Applicant: Doswell Projects Limited
Site: Land West of Yapton Lane, Walberton
Proposal: Non-Material Amendment pursuant to Section 96A of the Town and Country Planning Act 1990 (as amended) to amend the approved plans as submitted under the Reserved Matters application WA/52/24/RES by omitting garages, amendment to the GIA of 22 dwellings, replacing estate railings with post and rail fencing, the relocation of the pumping station and the inclusion of ASHP and PV Panels.

This covering letter accompanies a Non-Material Amendment (NMA) application in respect of Land West of Yapton Lane, Walberton, seeking to amend the approved plans under planning permission ref. **WA/52/24/RES**. The proposed amendments comprise the omission of the approved garages, amendment to the GIA of 22 dwellings, the replacement of estate railings with post and rail fencing, the relocation of the pumping station and the inclusion of ASHP and PV Panels.

PROJECT TITLE
Land West of Yapton Lane
DRAWING TITLE
PLOTS 12-16 Plans
DRAWING NUMBER
C9_23_38_PL_HTABB_P3

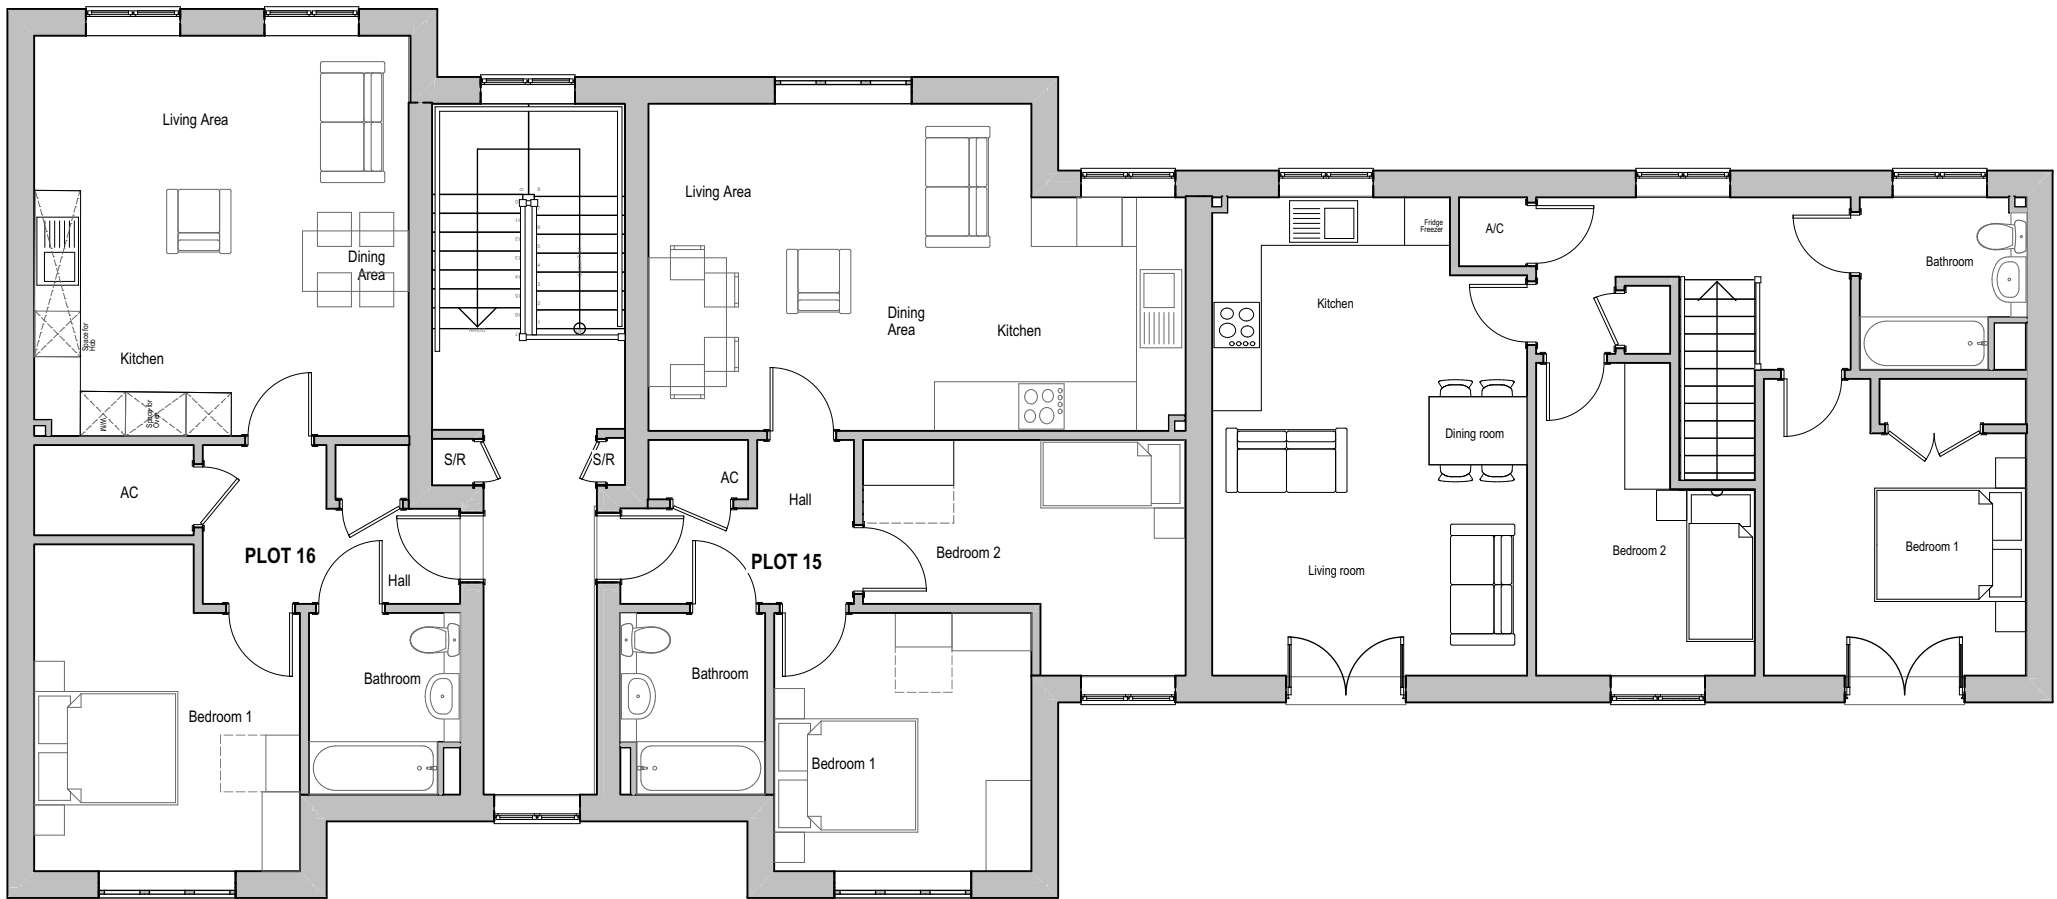
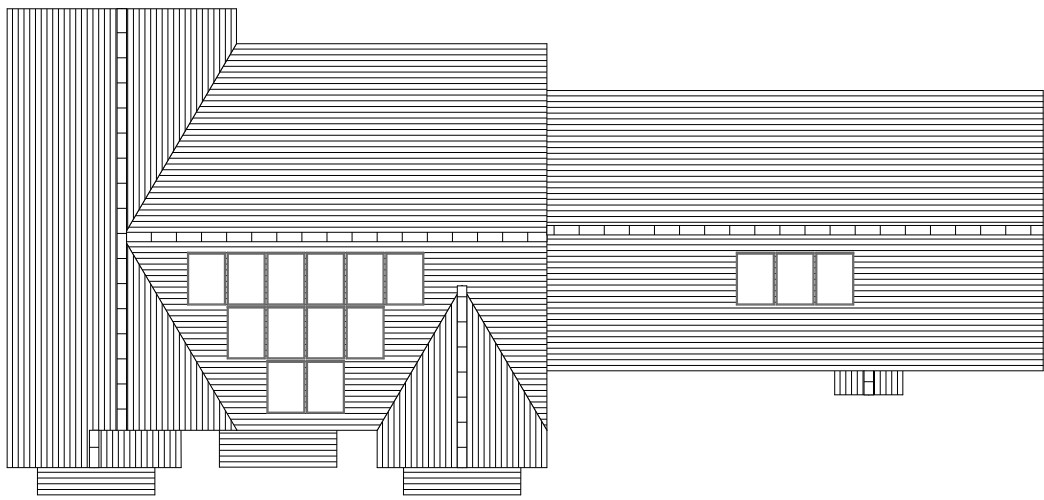
There have also been amendments to the rear fenestration, with the existing double patio doors replaced by a French-style patio door comprising a single hinged door with narrow fixed sidelights.

PROJECT TITLE
Land West of Yapton Lane
DRAWING TITLE
Plot 27
DRAWING NUMBER
C9_26_03_PL_HTB_P3

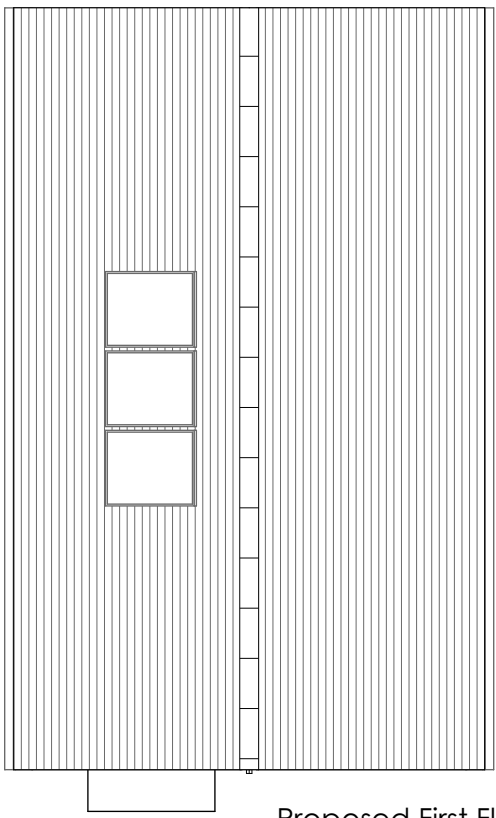
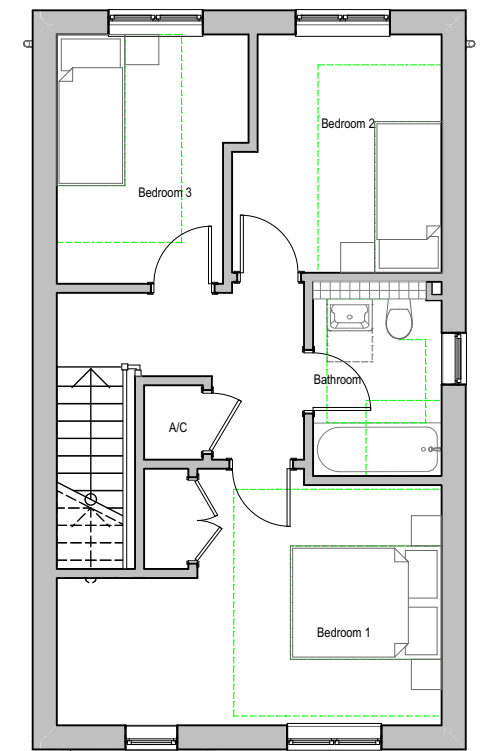
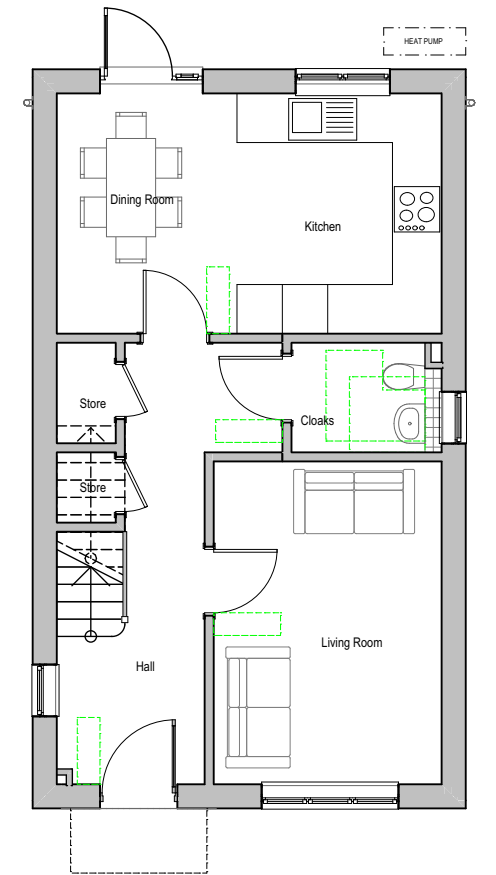
The plots proposed to be reduced in size are Plots 5, 6, 10, 11, 19, 24, 27, 28, 29, 30, 31, 34, 35, 36, 37, 38, 39, 40, 41, 42, 43 and 48. Further details of the proposed changes are provided within the corresponding plans and supporting documents submitted as part of this application.

Plots 37, 38

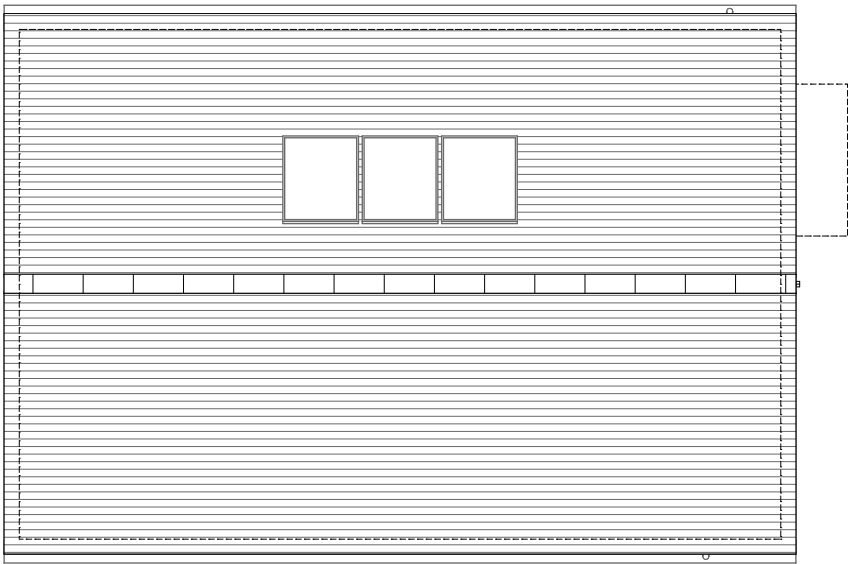
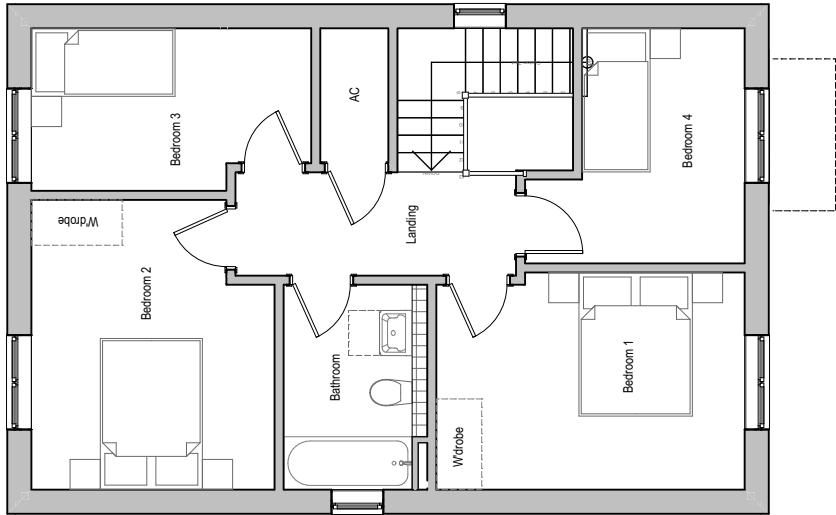
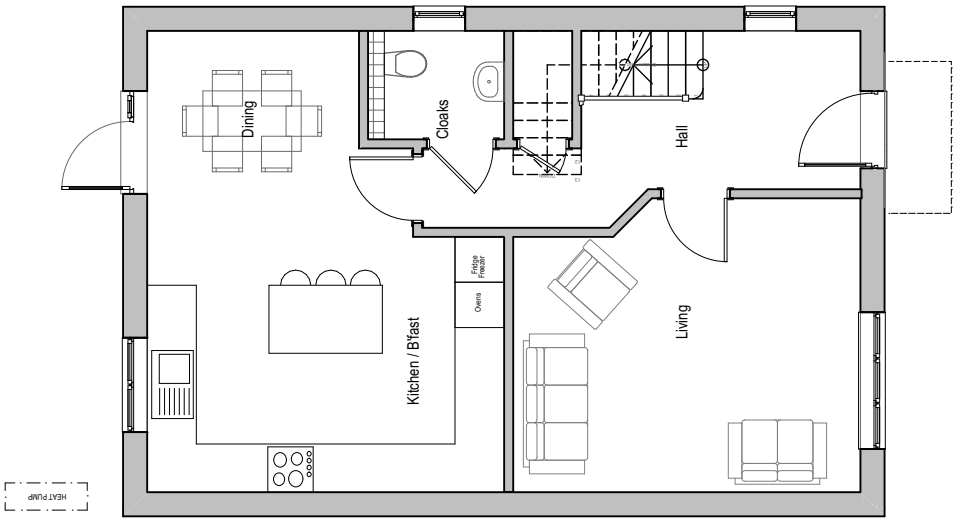
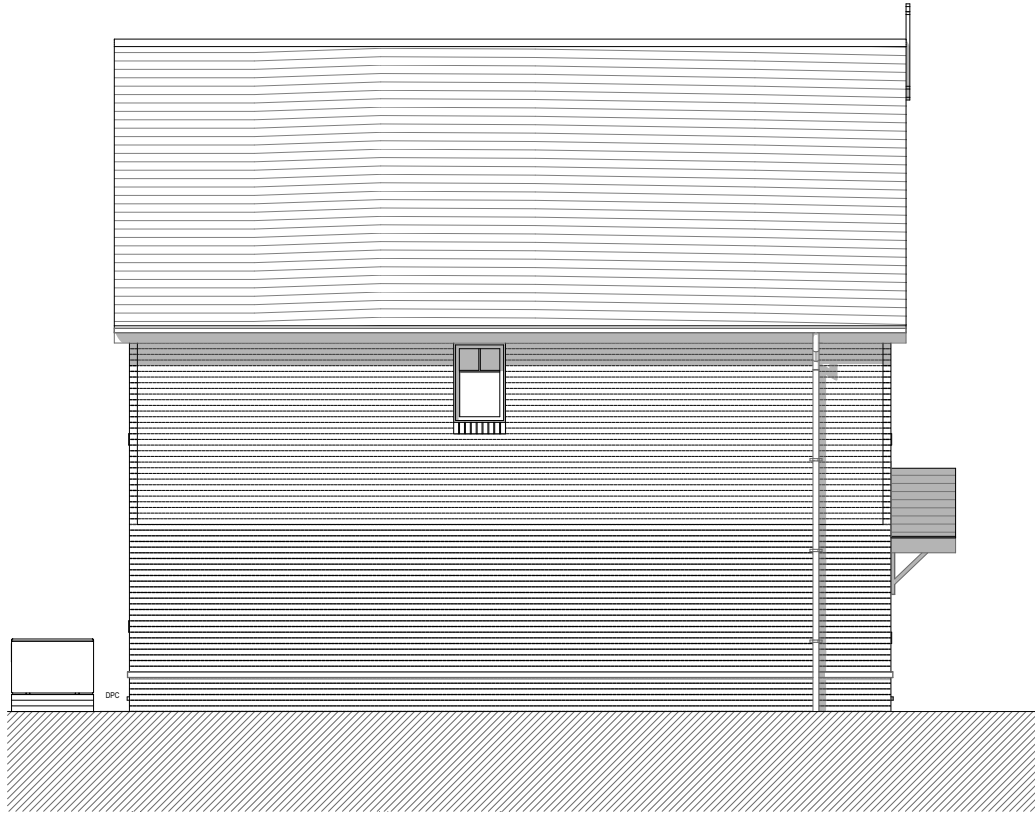
It is proposed that the garages serving Plots 9, 29, 30, 48, 43, 42, 41, 39, 38, 37, 36, 35, 34, 33, 32 and 31 are omitted as part of this NMA application.

Plot 31

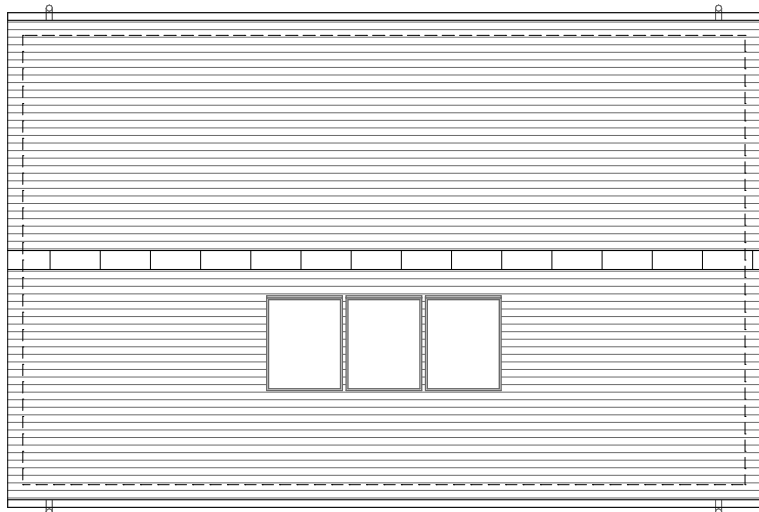
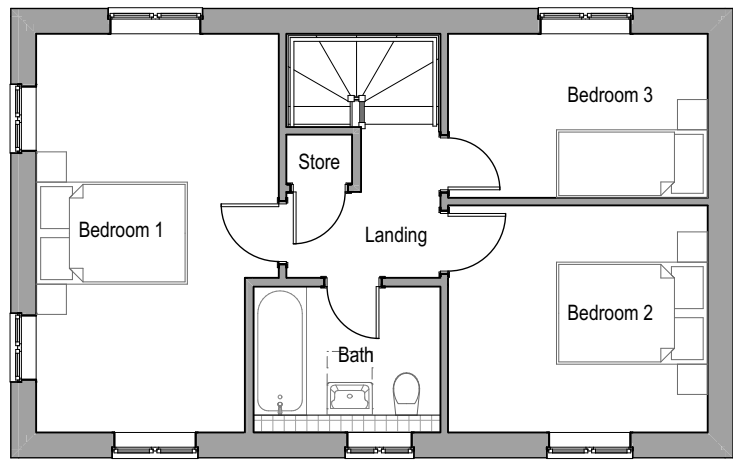
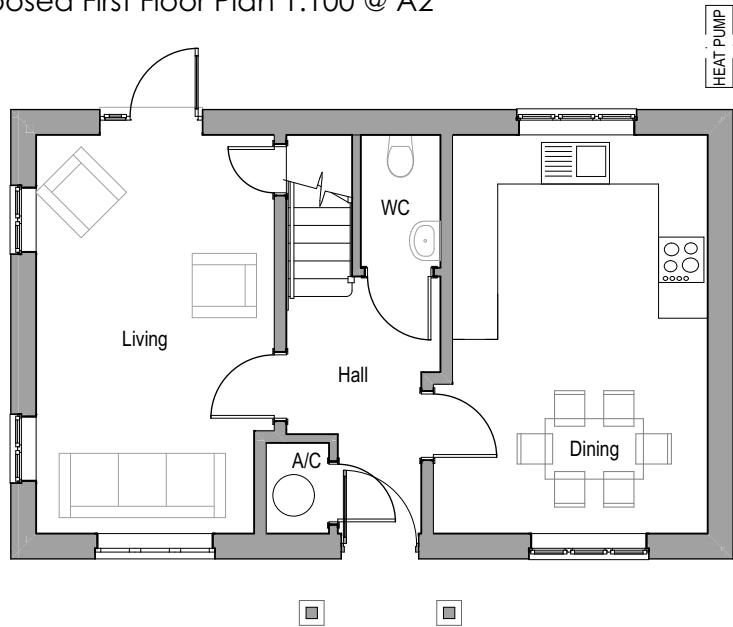
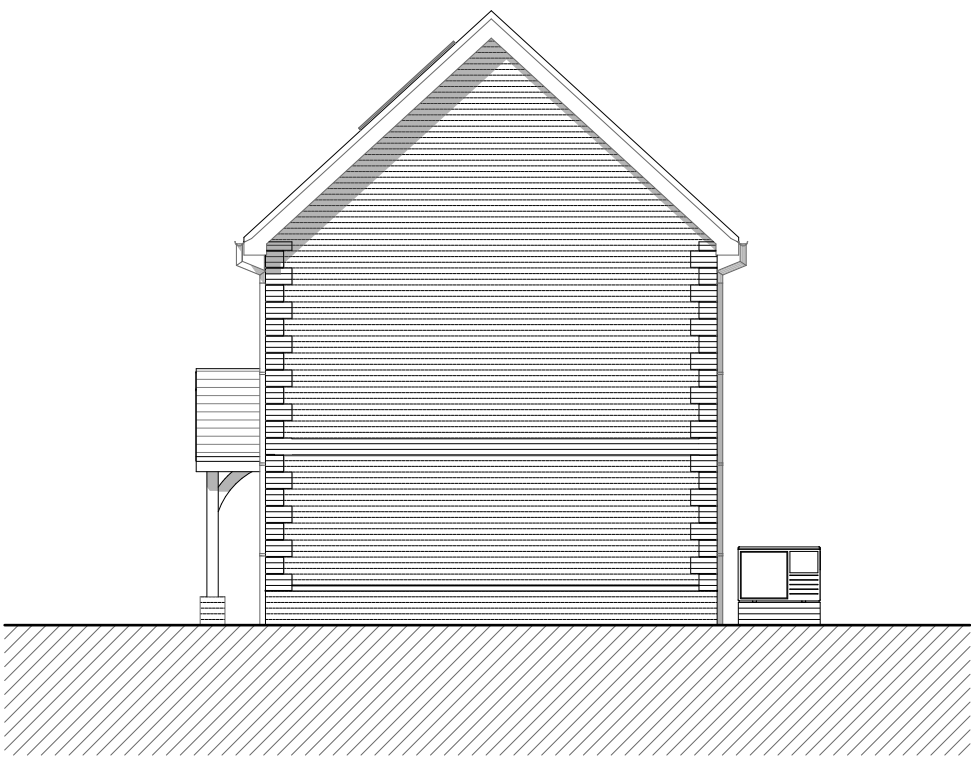
Because of the reductions in GIA, amendments to the roof forms of Plots 10, 11, 22, 23, 25, 26, 31, 42, 46 and 47 are also proposed. Further details of these changes are illustrated on the corresponding plans, elevation drawings and site plan.
